From: Laura Gibbons
Sent: 22 May 2019 13:49
To: Planning.Responses
Cc: Simon Davis
Subject: RE: Planning Consultation on Y/42/19/DOC

Engineers Comments Regarding Conditions 3 and 4:

APPLICATION NO: Y/42/19/DOC

Site Address: Yapton Metal Company Burndell Road Yapton BN18 0HP

GA Revised	NJH	25.04
Amendments	by	Date
Job Title	118 Burn/ADS/LH	
Drawing	Setting Out - Drainage	
Scale: 1:100 @ A1		
Drg.No.	ADS-025-C	*
Drawn by:	NJH	
Issued to:	Client	
Status:	Construction	
Date	25.04.19

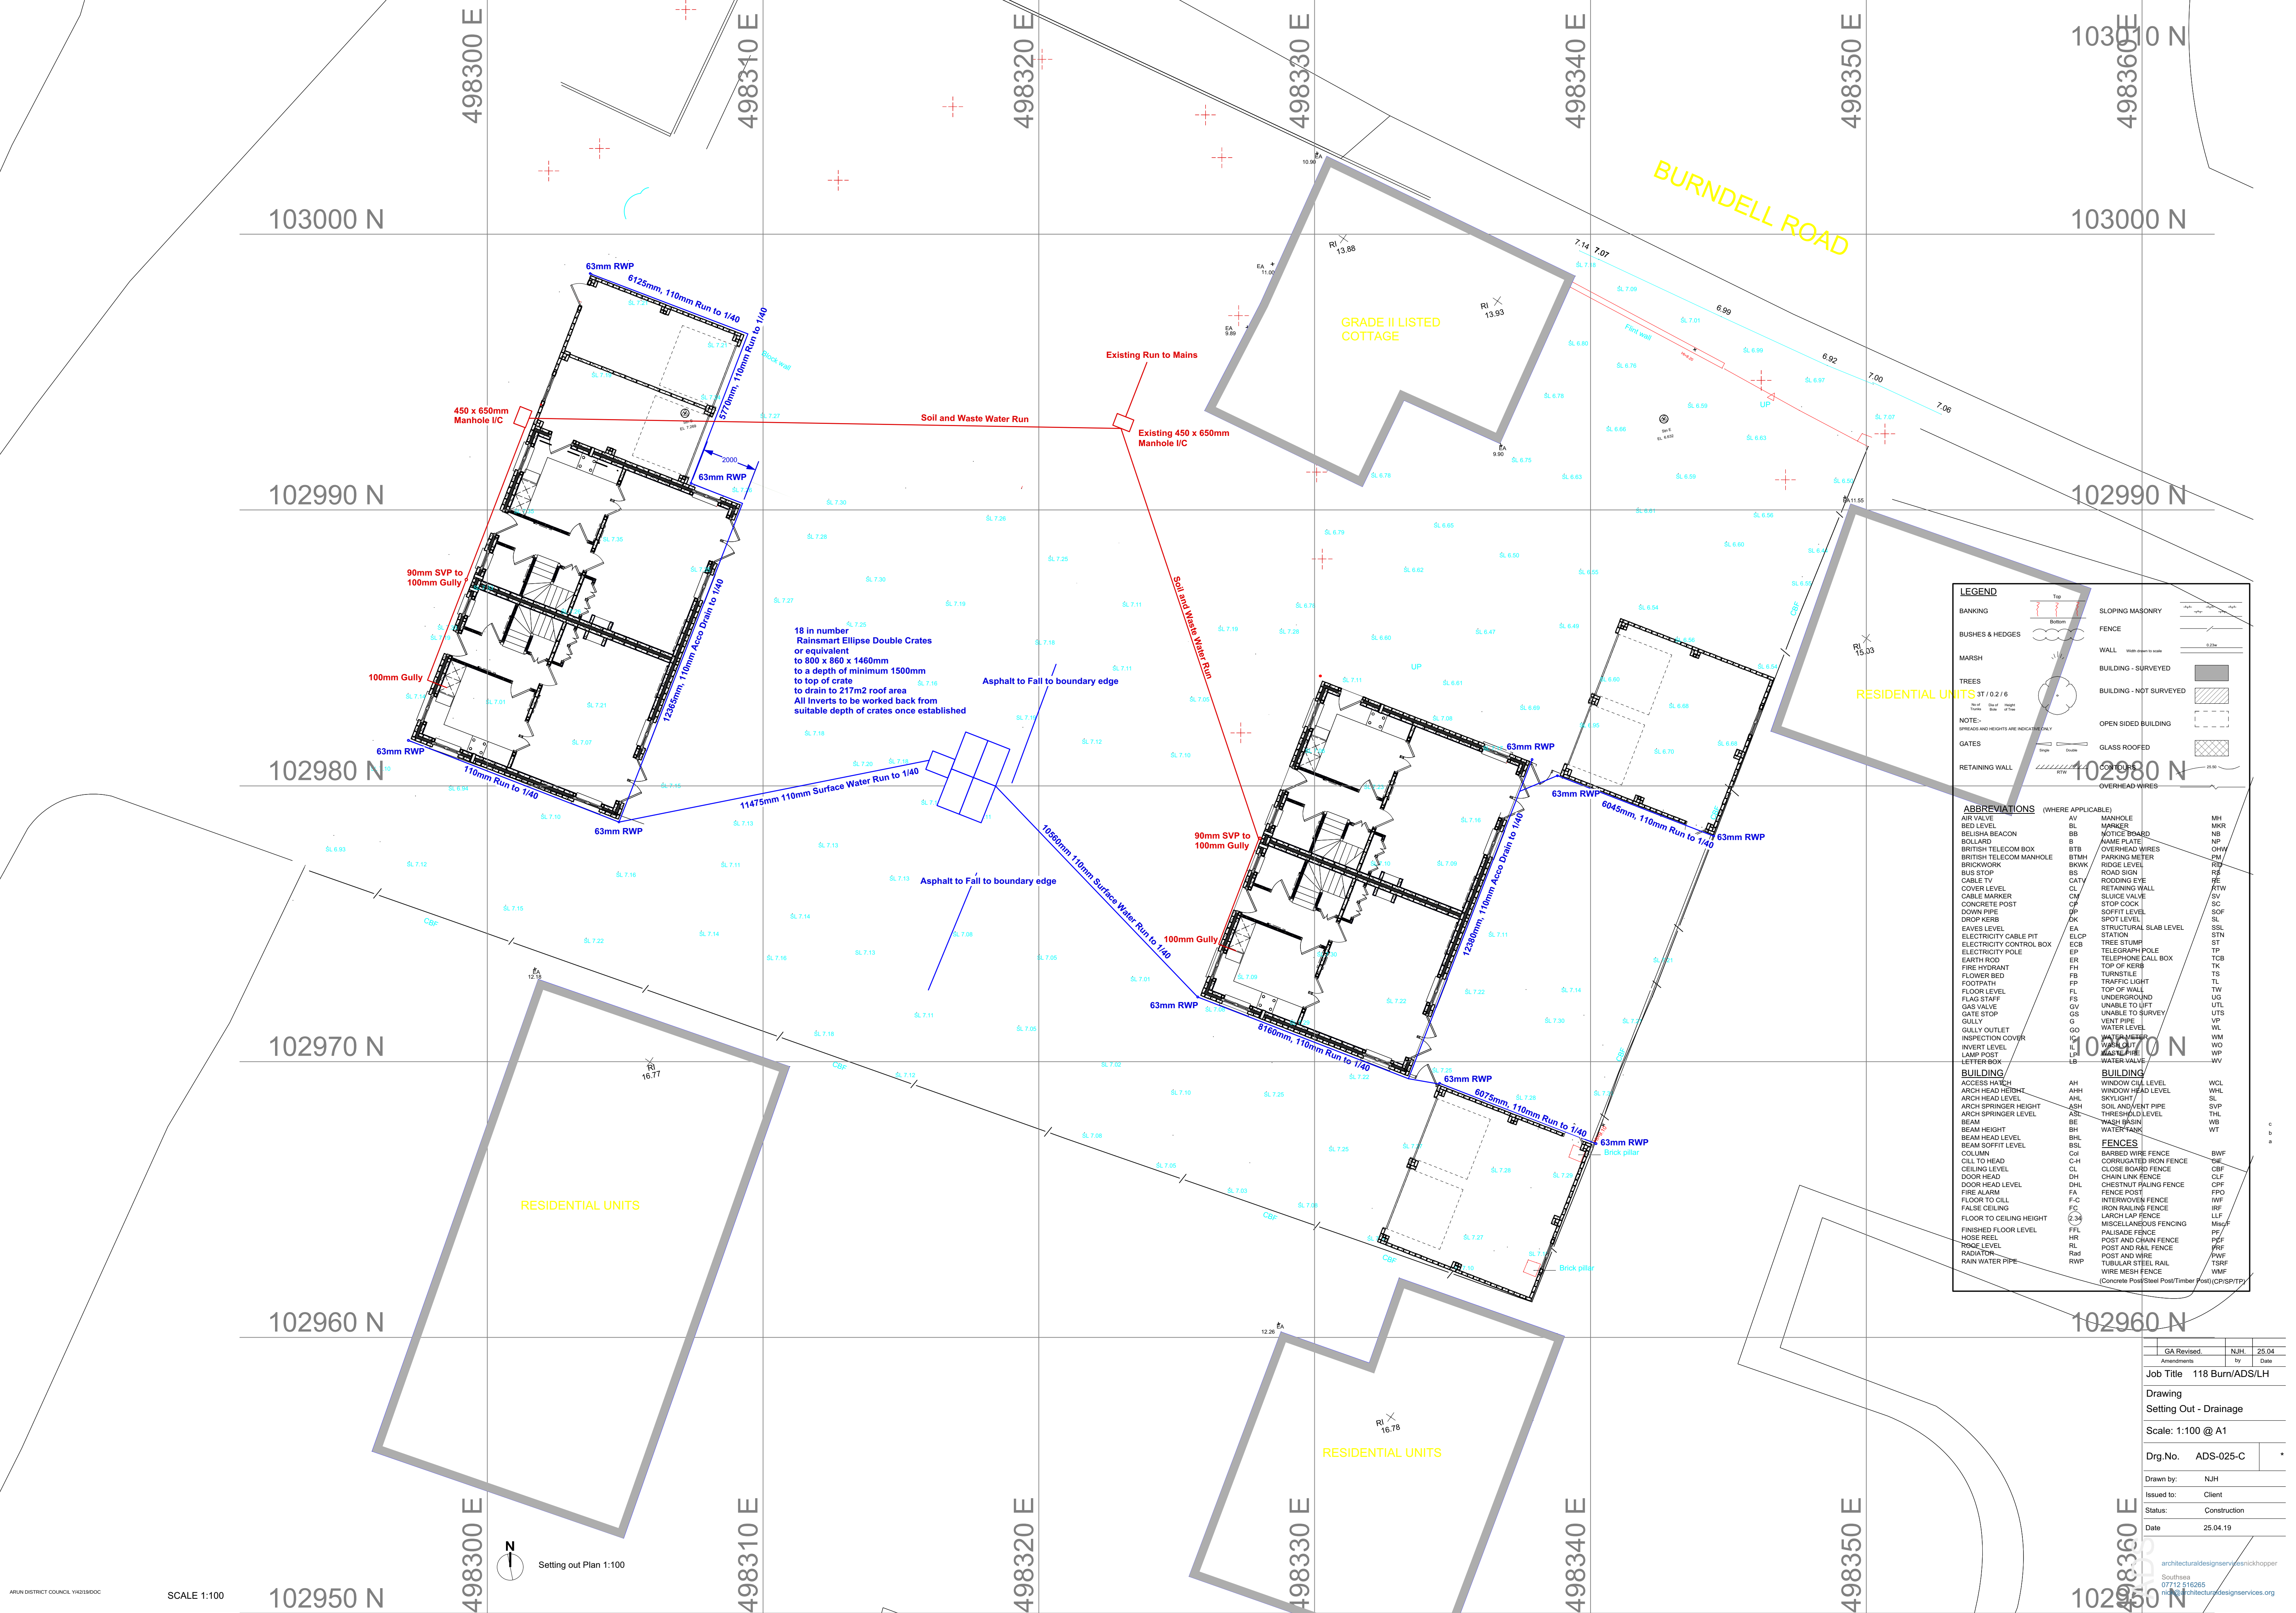
- Winter groundwater monitoring results must be provided.
- Winter infiltration testing (in accordance with BRE365) results must be provided.
- Calculations must be provided demonstrating there is adequate capacity to contain water on site for the 1 in 100 year plus climate change event.
- Construction detail drawings must be provided.
- A maintenance manual must be provided, similar to that set out in the suds manual.
